A428 Black Cat to Caxton Gibbet improvements

9.88 Schedule of Changes to the Environmental Masterplan

Regulation Reference:	Rule 8(1)(k)
Planning Inspectorate Scheme Reference	TR010044
Application Document Reference	TR010044/EXAM/9.88
Author	A428 Black Cat to Caxton Gibbet Improvements Project Team, National Highways

Version	Date	Status of Version
Rev 1	14 December 2021	Final for Deadline 6
Rev 2	25 January 2022	Final for Deadline 9

Drawing Number: HE551495 - ACM - ELS - P04
 Location: GEN_SW_Z_ZZ_DR-LV-0015
 I Type: I Role: I Number

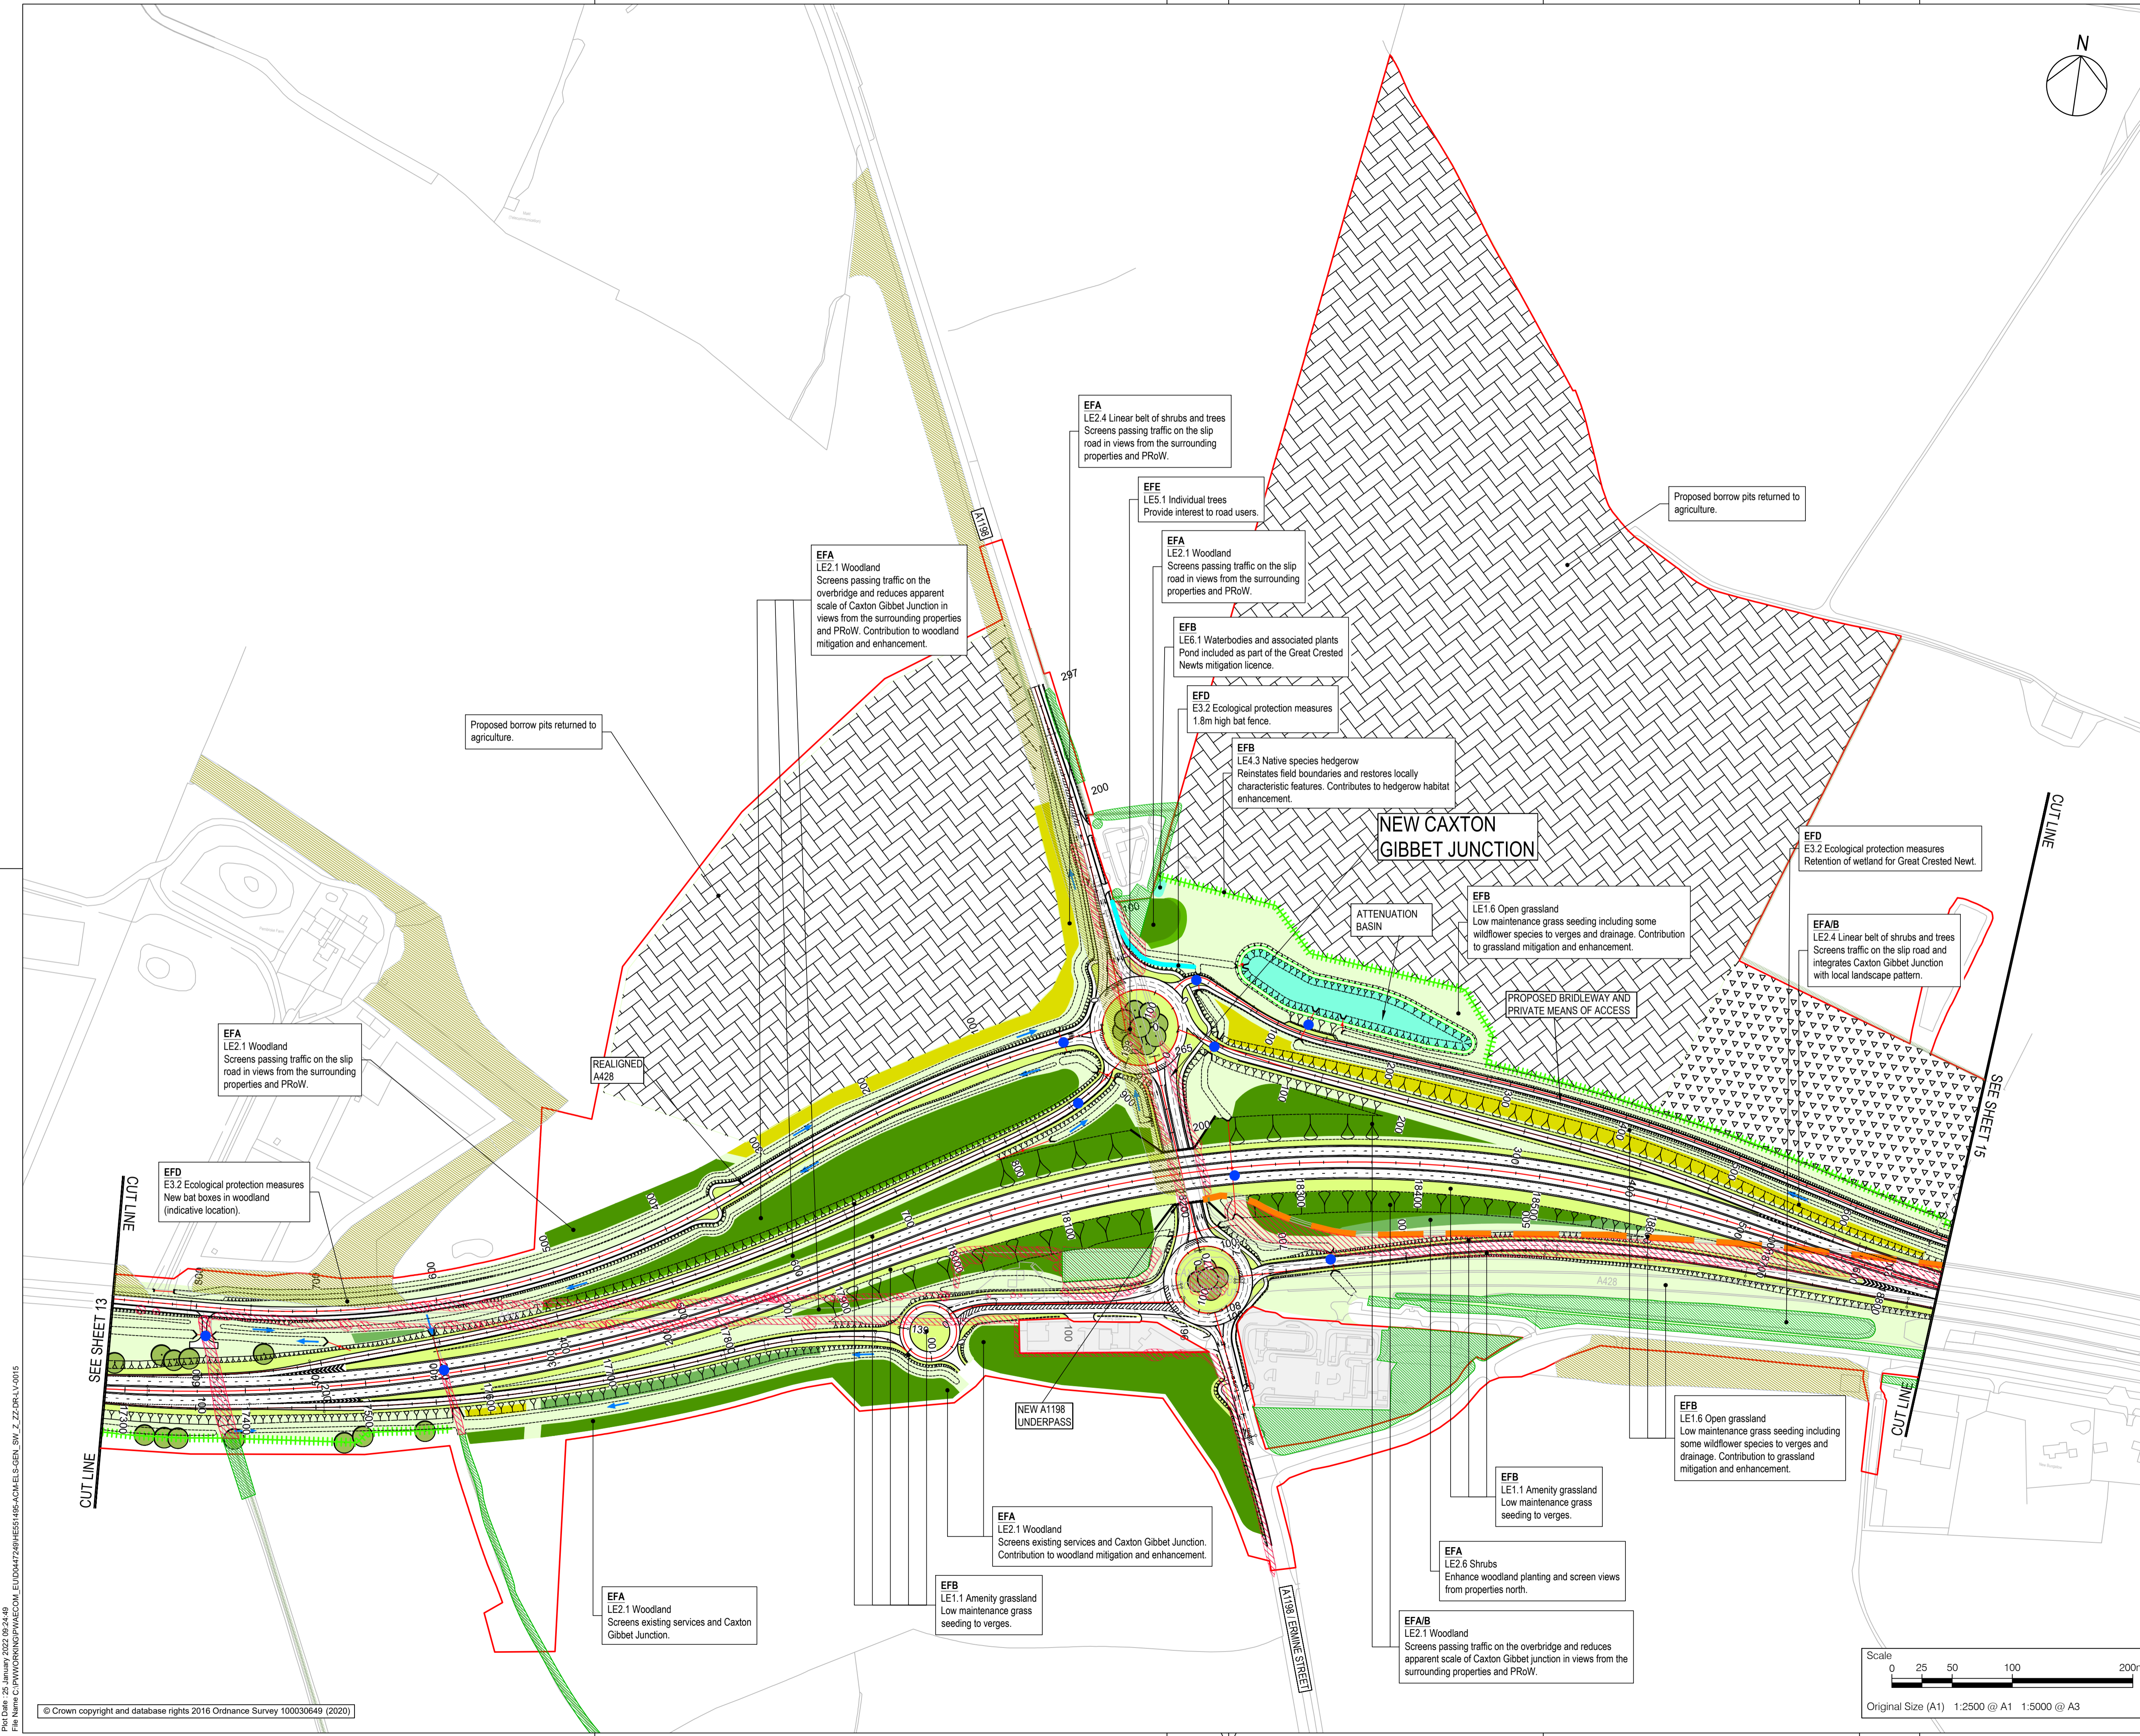
28	DR-LV-0015 between chainage 1 - 100	National Highways	Review of the masterplan noted that some of the fencing structures were not visible or not considered of the correct type to act as bat mitigation.	Further labelling of figure to highlight where fencing has been included to encourage bats flying from the north and east into new habitat to the east of the Scheme and not across the proposed carriageway.	Deadline 9	Figure 2.4v4
29	DR-LV-0006 between chainage 6600 - 6700	National Highways	Review of the masterplan noted that a pond provided for Great Crested Newt mitigation was incorrectly shown on land temporarily acquired.	Pond and associated grassland moved to intended location within permanent landtake adjacent to woodland planting.	Deadline 9	Figure 2.4v4
30	DR-LV-0010 between chainage 10200 - 10300	National Highways	Review of the masterplan noted that an attenuation pond had been incorrectly labelled and the pond for Great Crest Newt mitigation was not shown.	Pond for Great Crested Newt mitigation moved away from attenuation pond. Location in this area to be refined during detailed design.	Deadline 9	Figure 2.4v4
